CITY OF ALBUQUERQUE

**Re: Opus Transport Apartments
Traffic Impact Study (M15D023H)**
Engineer's Stamp 7-10-24
Via email jroberts@tierrawestllc.com

The subject Traffic Impact Study (Study) received on July 11, 2024, has been reviewed by the City of Albuquerque Planning Development Transportation Section. The City has the following comments to be included in the Final TIS.

Figure 4: Proposed Striping and Intersection Mitigation

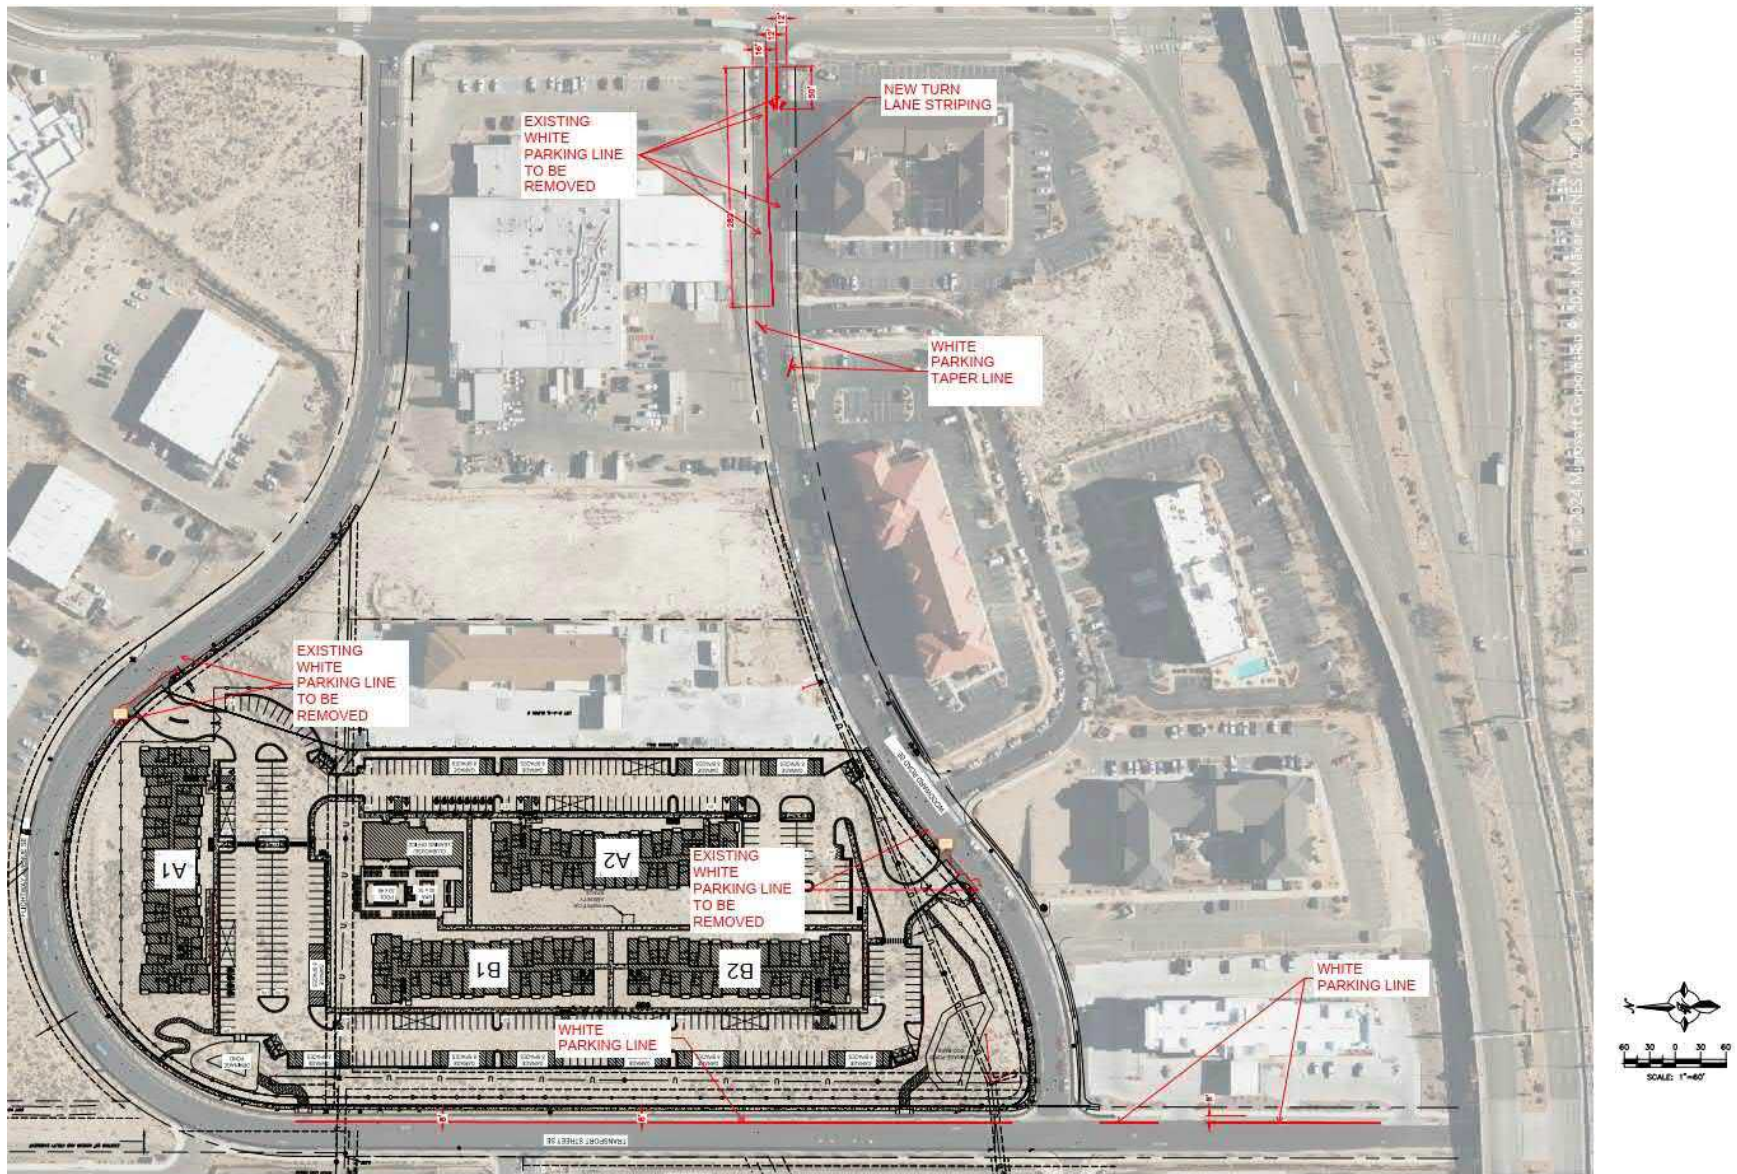
1. Please include the striping exhibit V2.
2. Revise the analysis at Woodward Rd and University Blvd using eastbound right and left turn lanes.

Response: Tierra West LLC. has attached the revised striping exhibit V2 to this letter as well as included it within the body and appendix of the report to reflect the recommended improvements in striping for on street parking and the installment of an additional eastbound left-turn lane on Woodward Rd. at University Blvd.

Response: Tierra West LLC. confirms the revised analysis for the intersection of Woodward Rd. at University Blvd. The mitigated improvements of the Woodward Rd. at University Blvd. intersection were successfully evaluated by separating the shared eastbound left-turn and right-turn lane while increasing the storage capacity of the eastbound approach volume. The mitigation measures significantly reduced the V/C ratio, delay in seconds, and the 95th percentile queue length compared to the horizon year build volume under existing conditions. These improvements also include the elimination of the on-street parking along the north and south side of Woodward Rd.
